Gatwick Northern Runway Development Consent Order Application TR020005

Reigate & Banstead Borough Council 20044474

**Principle Areas of Disagreement Summary Statement (PADSS)
Version 2 Deadline 2 Submission with Tracked Changes**

26 March 2024

DRAWING TITLE
 Surface Access Tree Removal and Protection Plan
 Appendix 8.8.1 Annex 4
 Sheet 5 of 9

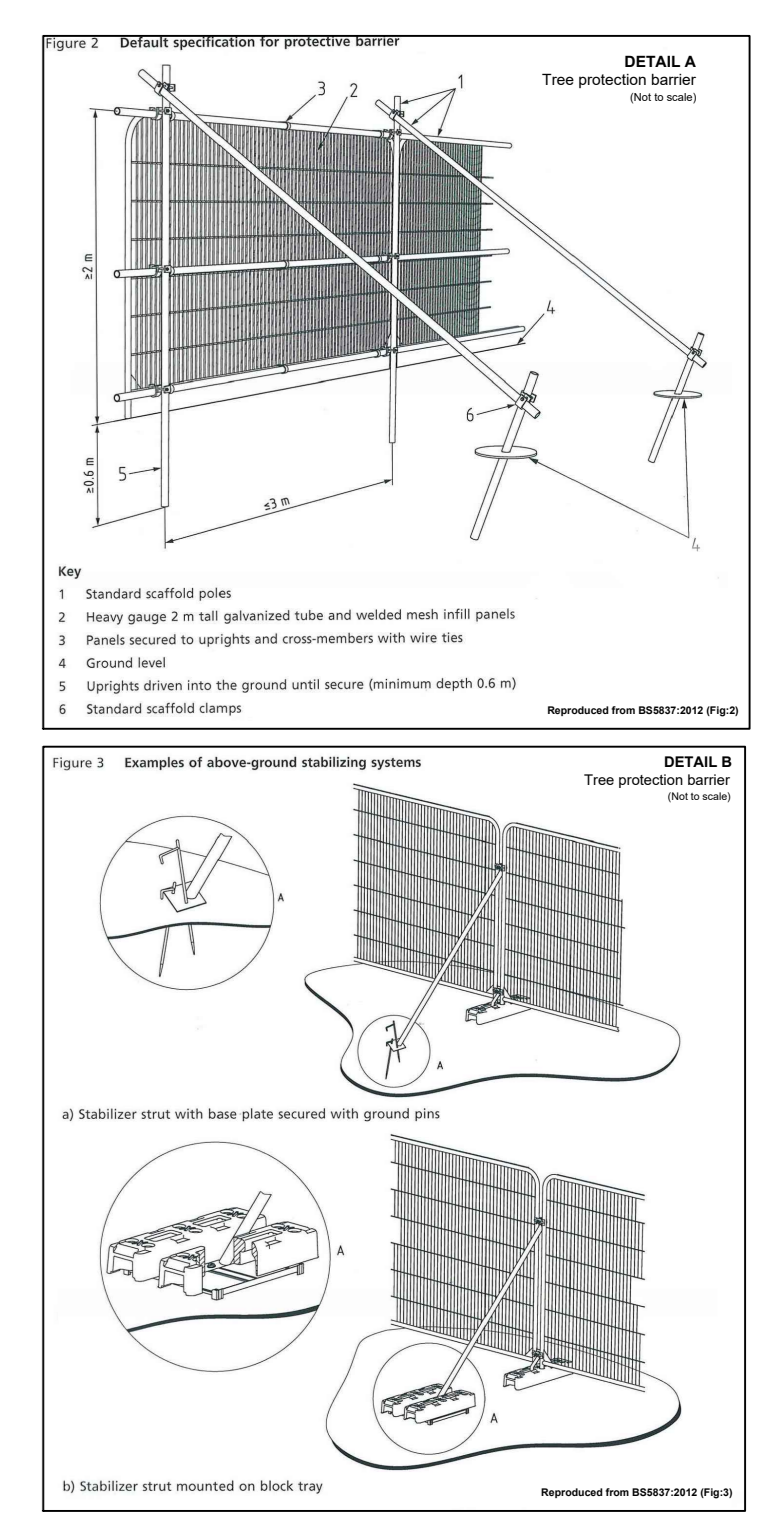
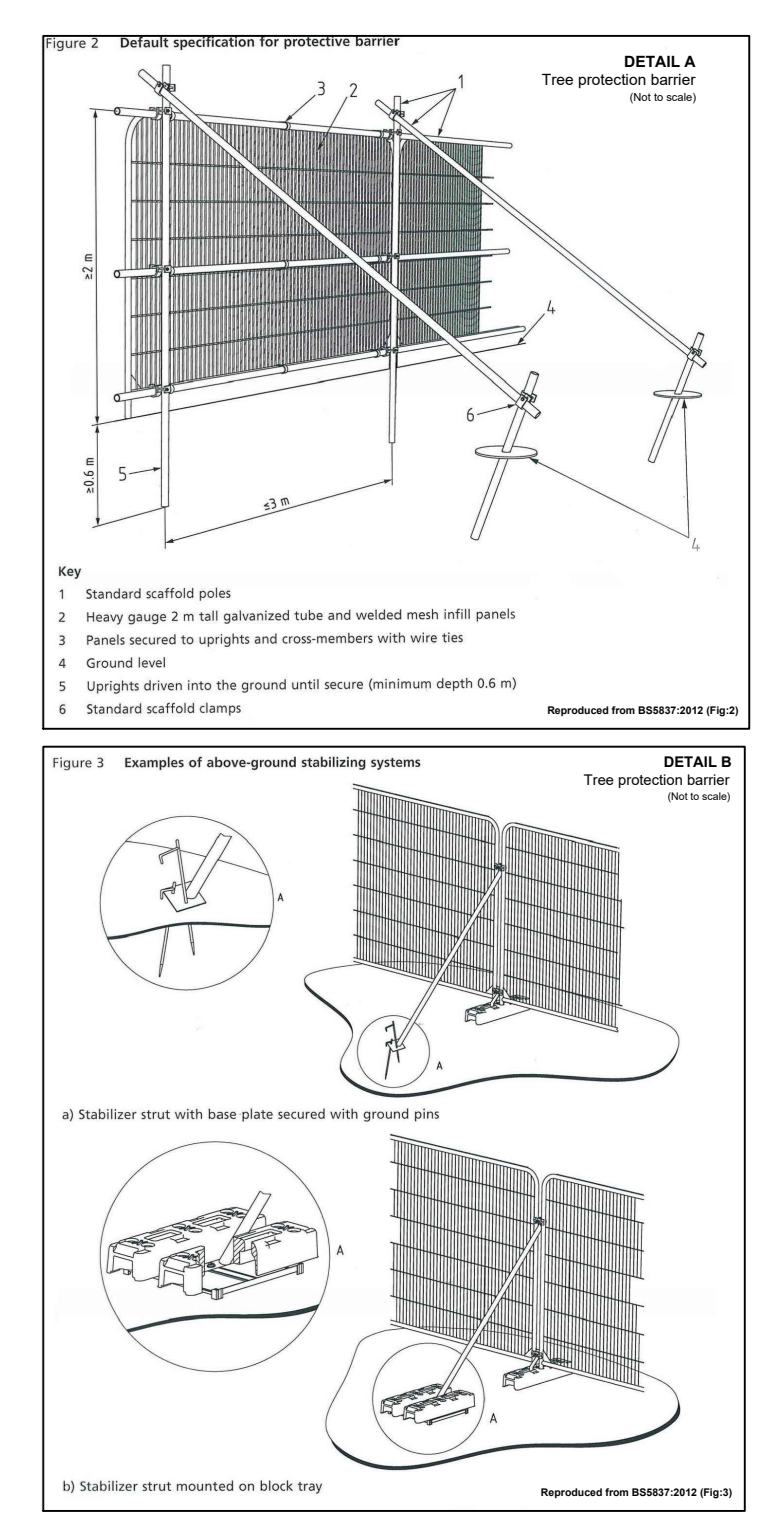
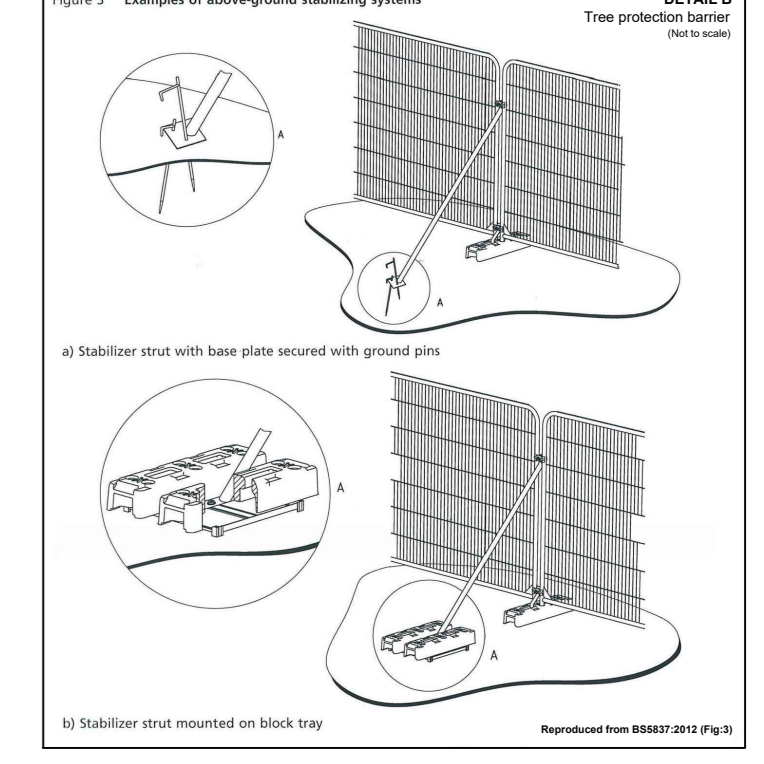
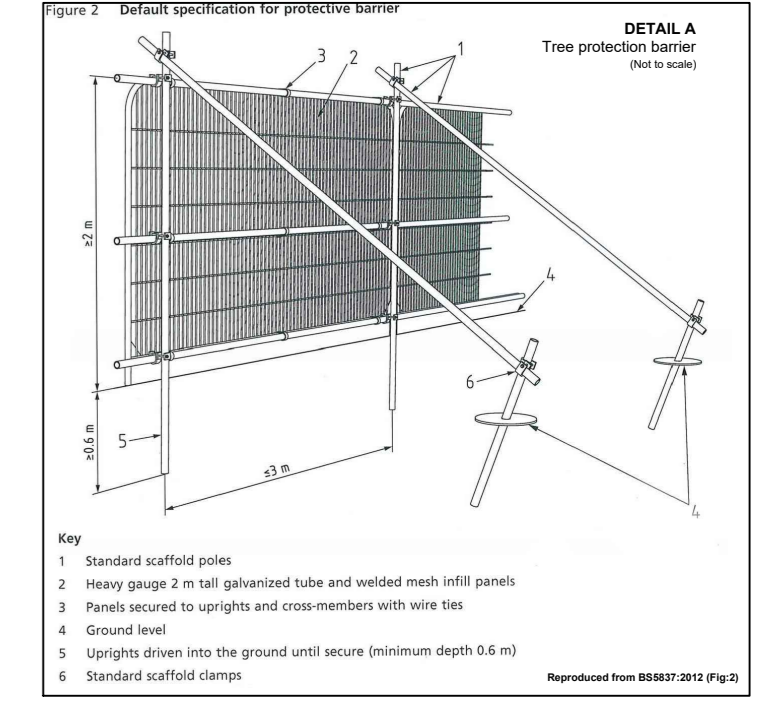
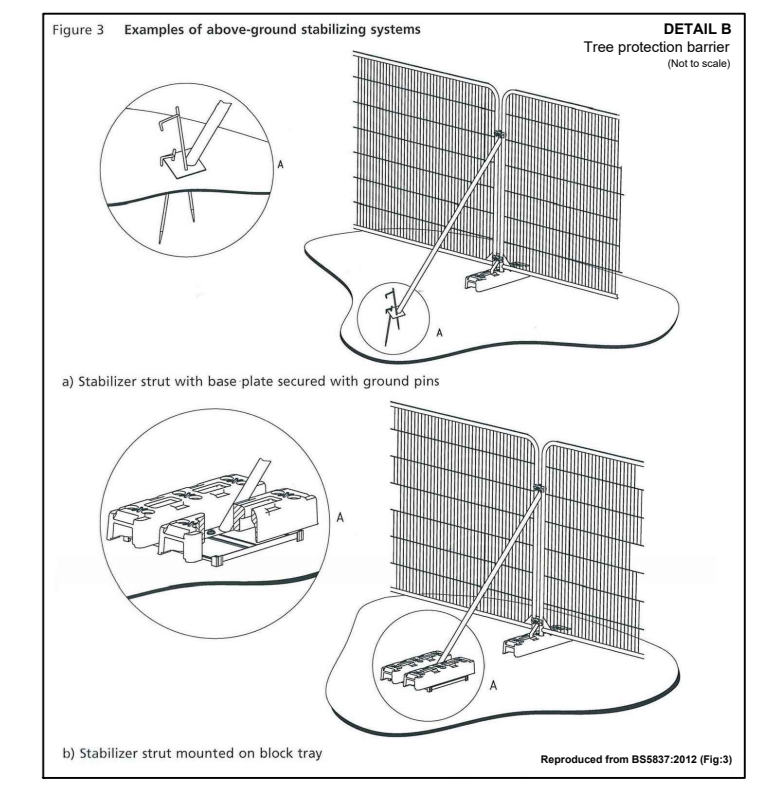
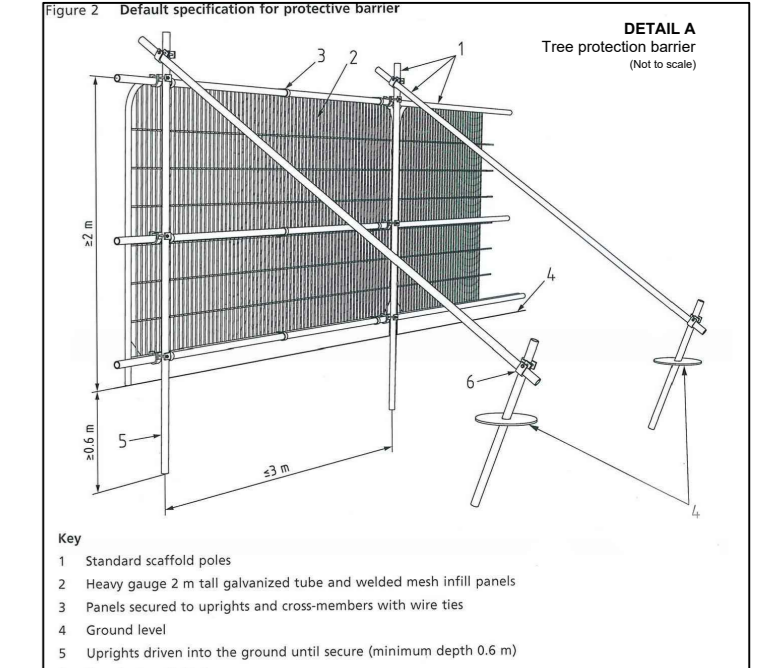
2.	Loss of Vegetation Barrier along A23	The verdant vegetation barrier from Church Meadows, Riverside Garden Park through to the M23 junction has taken more than a generation to achieve with the result that a highly significant separation barrier has been grown between Horley and the airport along with providing a classic 'parkway' appearance. However, this has been omitted from the description.	Inclusion sought together with details of its replacement. <u>Further iteration of the oLEMP required.</u>	Likely
NEEDS CASE
